**WEST SUSSEX COUNTY COUNCIL  
STRATEGIC PLANNING CONSULTATION**

**DATE: 9th February 2017**

**SUBJECT: LU/182/15/PL - Variation of conditions 4, 6, 7, 8, 39 and 42 imposed under planning reference LU/47/11/ relating to list of plans, illustrative masterplan, CHP plant building, Design Statement, bus stops & traffic improvements.**

**LOCATION: Land North of Toddington Lane, Littlehampton, BN17 7PP.**

Amended Land Use Parameter Plan

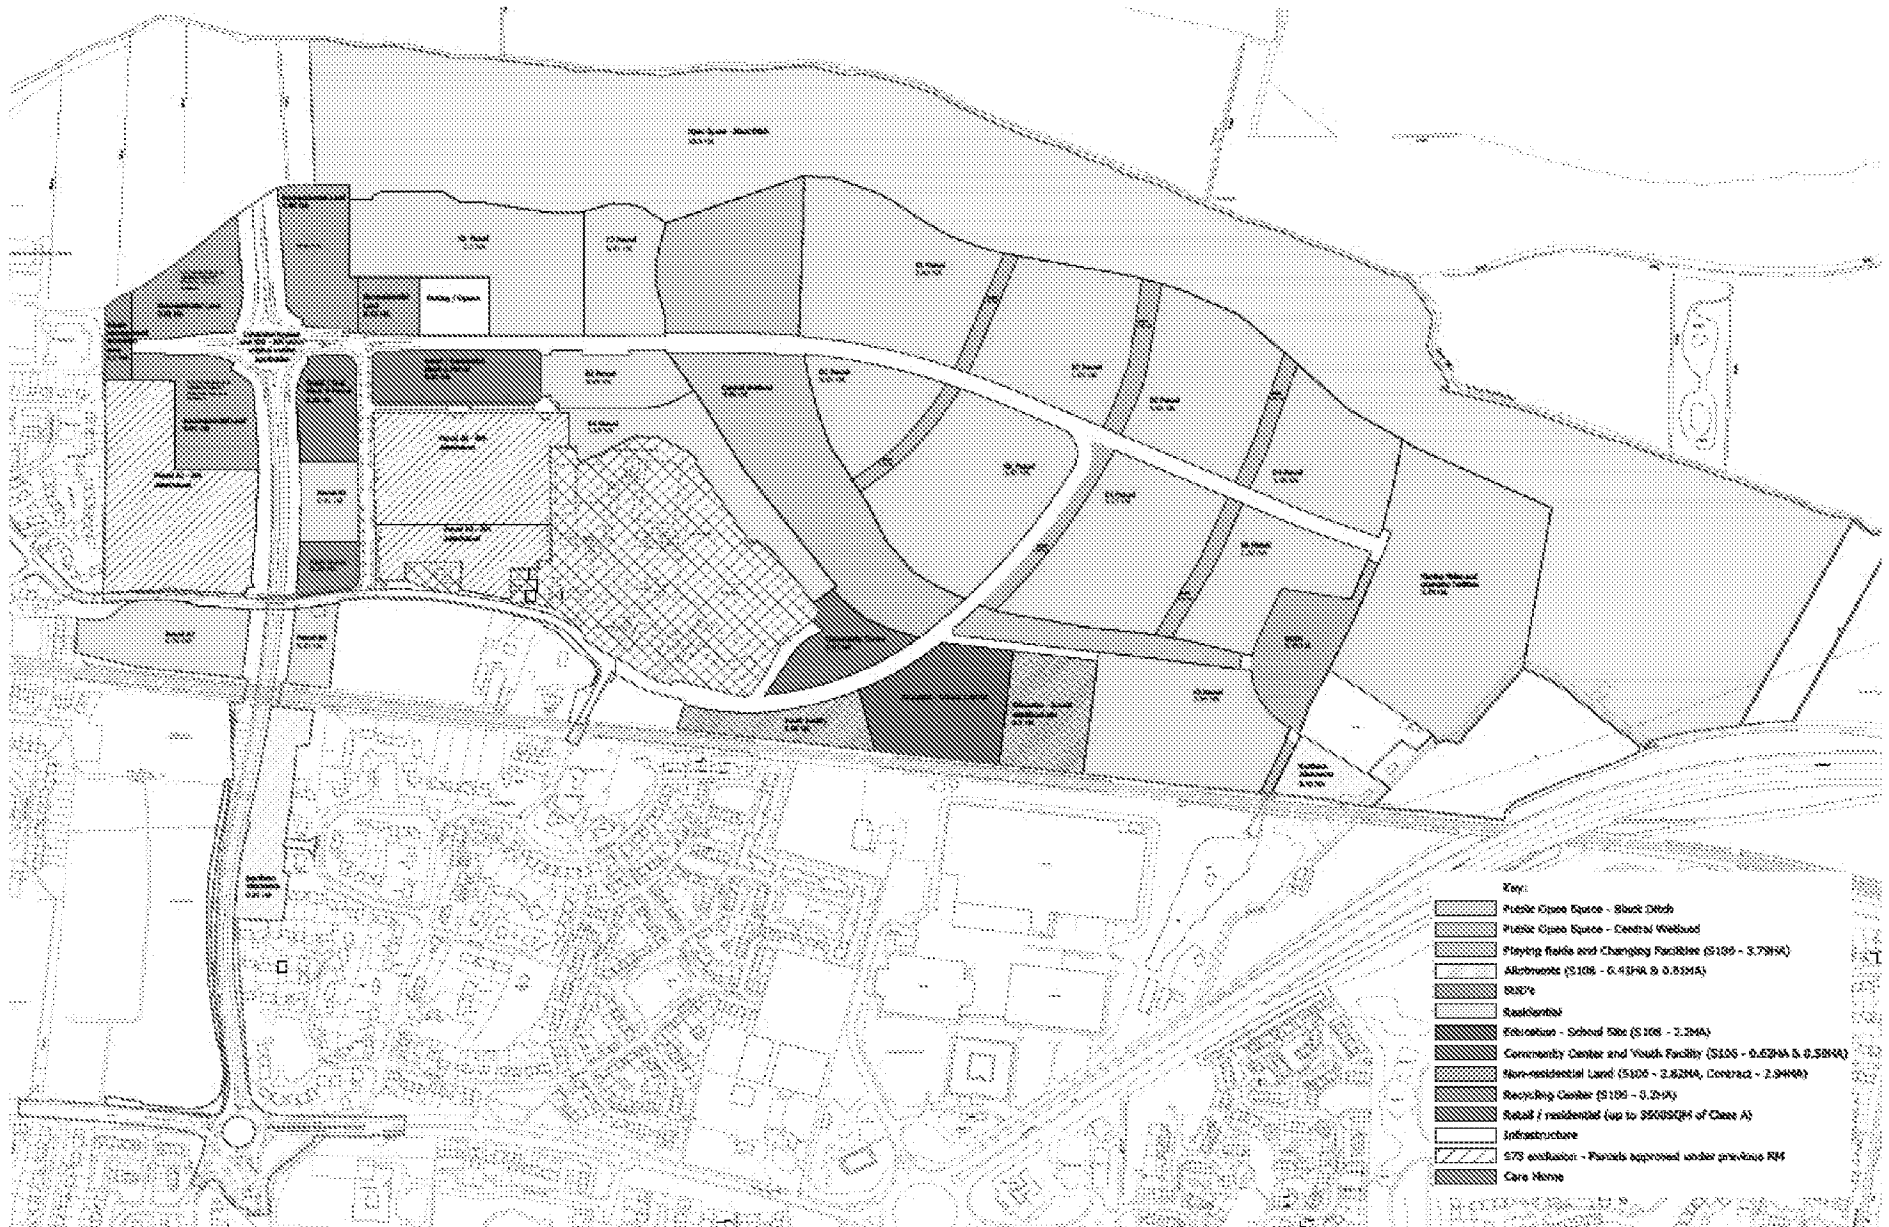
- *Drainage (overall)* – Comments should be sought separately from drainage engineers.
- *Drainage (at interface point with proposed Lyminster By-Pass)* – The land use parameter plan has identified 15m offset zones either side of the Lyminster Bypass on the advice of an acoustic consultant. It is intended to use some of these areas as a location for surface water drainage attenuation. The surface water drainage is limited to greenfield run-off prior to outfalling into the Black Ditch. Preliminary design work has been undertaken to confirm that the 15m offset zones provide enough space for the attenuation but further detail is required before this constraint can be accepted.

Approved Vehicular Access Parameter Plan

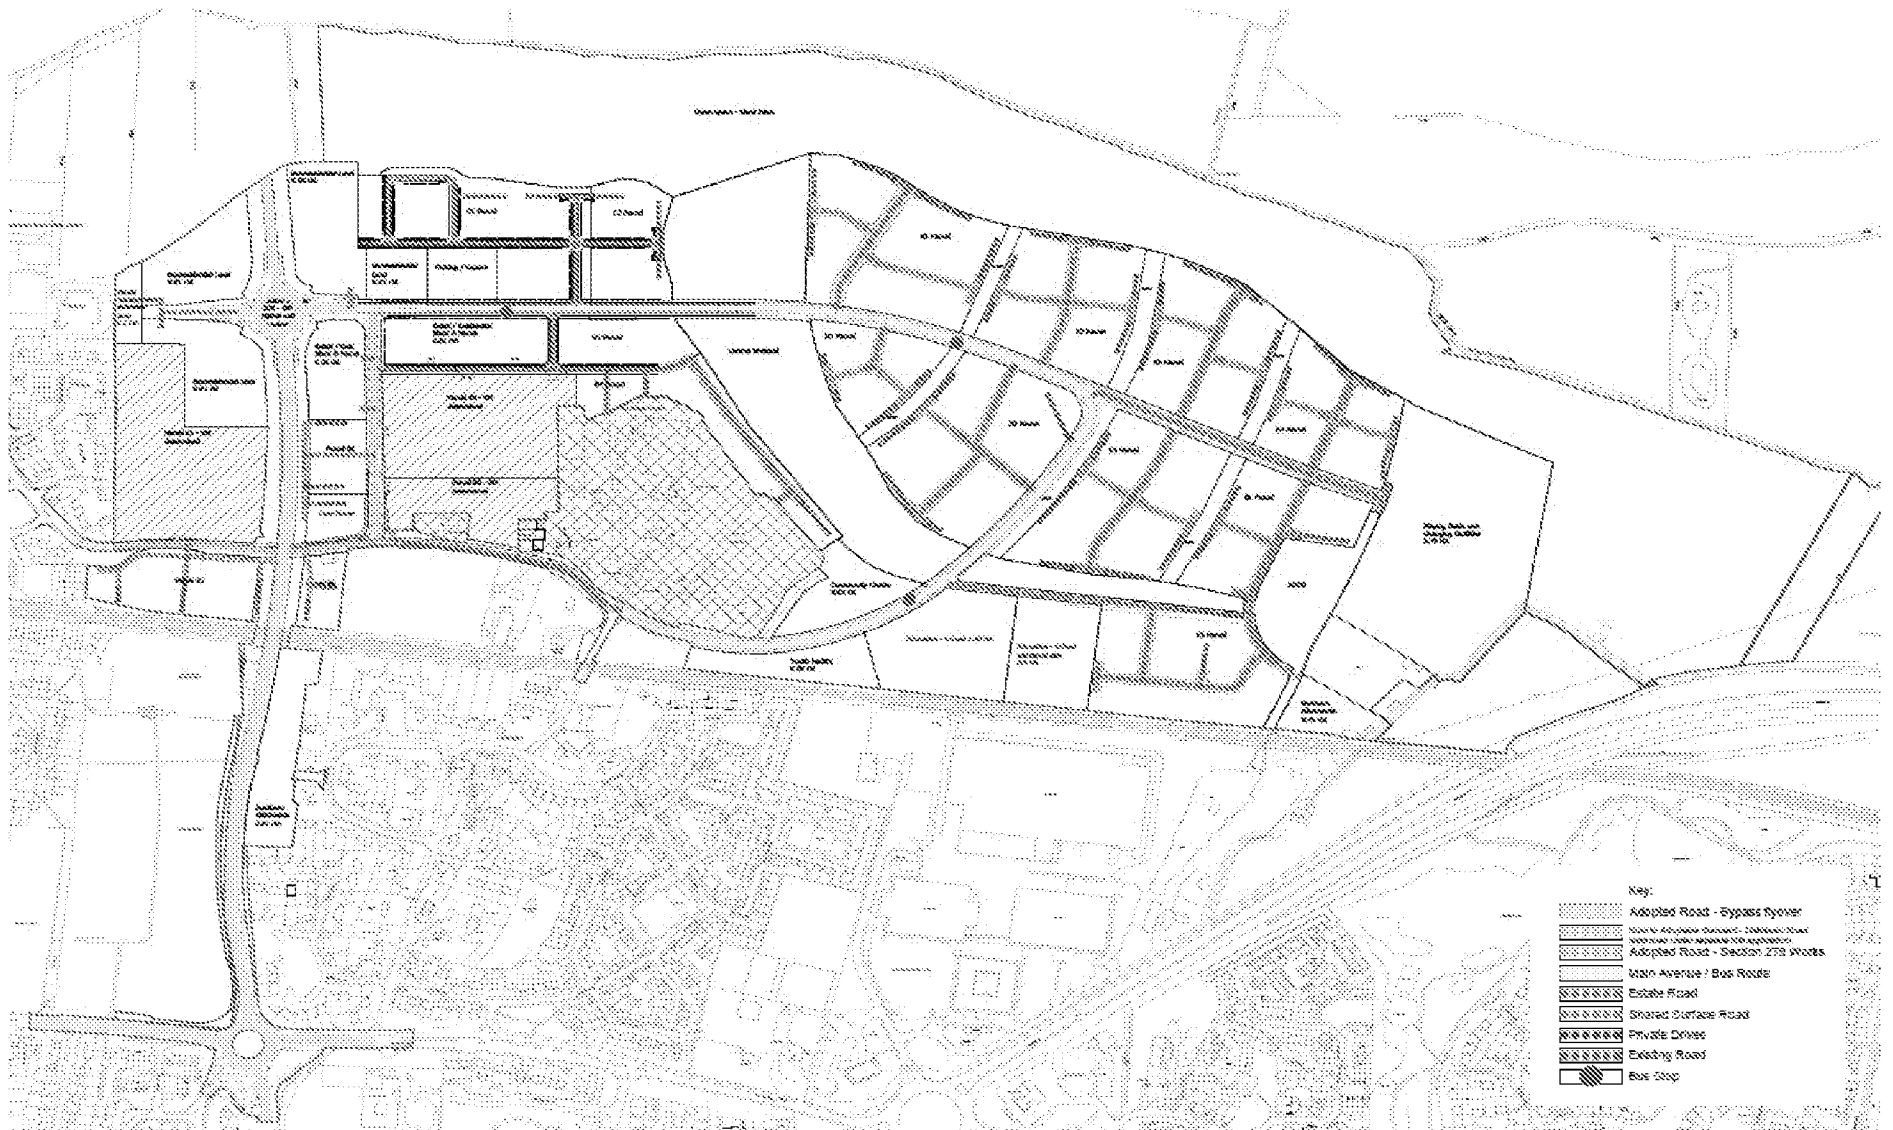
- Road widths (residential access roads – **NOT** Strategic Roads nor loop/spine road) – Minimum road width shall be 4.8m. For reasons of safety and accessibility, 4.1m wide roads/access drives (as quoted in the Development Framework Document) should not be provided.
- Visibility splays – To comply with recorded traffic speeds and informed by Manual for Streets and/or Design Manual for Roads and Bridges as appropriate.
- Extent of road adoption – WSCC will adopt roads in red as shown below given their strategic nature (blue line is existing adopted public highway):
